File No: SF17/8626
Ref No: DOC17/95419

Request for comment on Section 96(2) Modification Application to Stage 1 Demolition Works for Western Sydney Stadium, 11-13 O'Connell Street, Parramatta (SSD 7534)

Rajeev Maini
Manager, Conservation
Heritage Division
Office of Environment & Heritage
As Delegate of the Heritage Council of NSW
24 February 2017

Figure 20 - Localised Site Flooding Mitigation

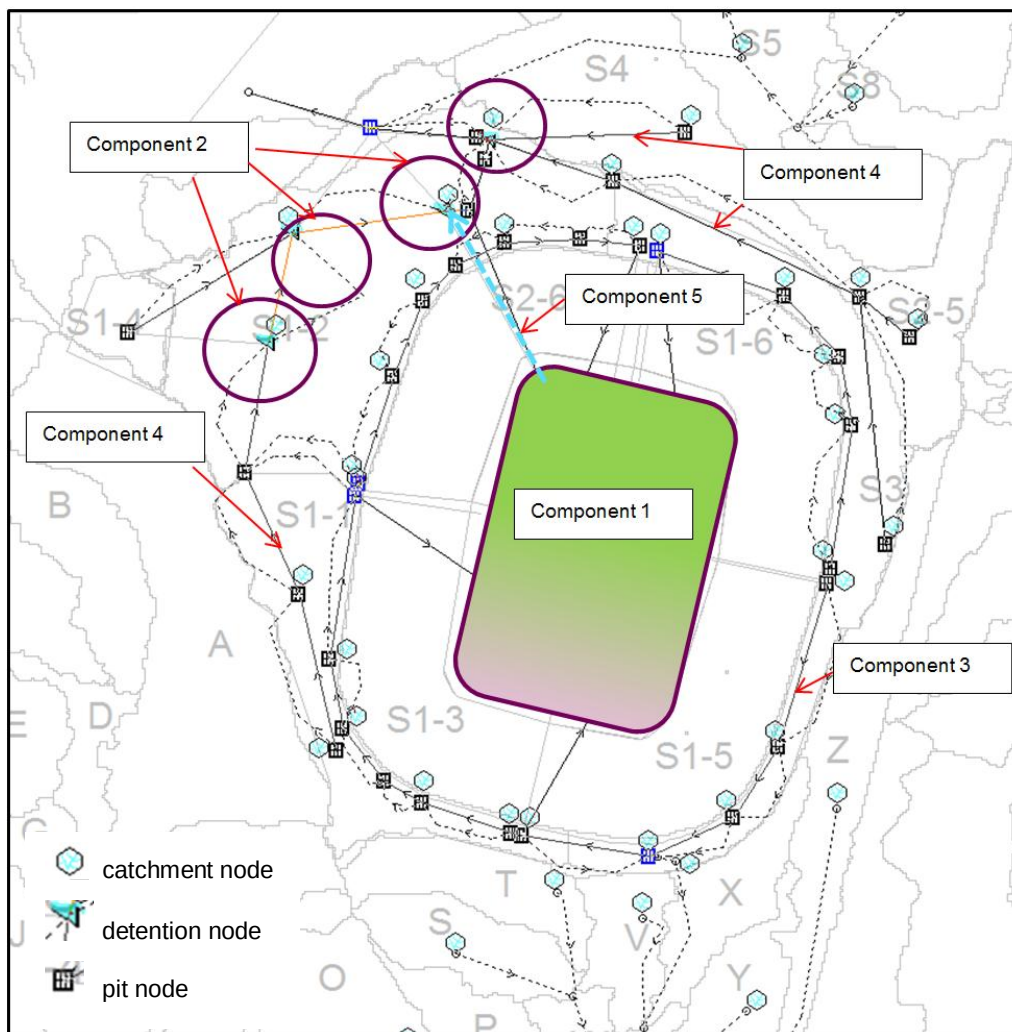
The project is located adjacent to Parramatta Park. A section of the project encroaches on the World Heritage Area buffer zone for the Parramatta Park and Old Government House portion of the Australian Convict Sites listing. This area is proposed to contain a stormwater element and outfall into Parramatta River. It is considered that these works should be sensitively designed to avoid this World Heritage Area buffer zone and ensure that the significant values of this area are protected.

1. All current heritage conditions of approval shall remain unchanged.
2. The stormwater elements, and its outfall into the Parramatta River shall be sensitively designed to avoid the World Heritage Area buffer zone associated with Parramatta Park and Domain.
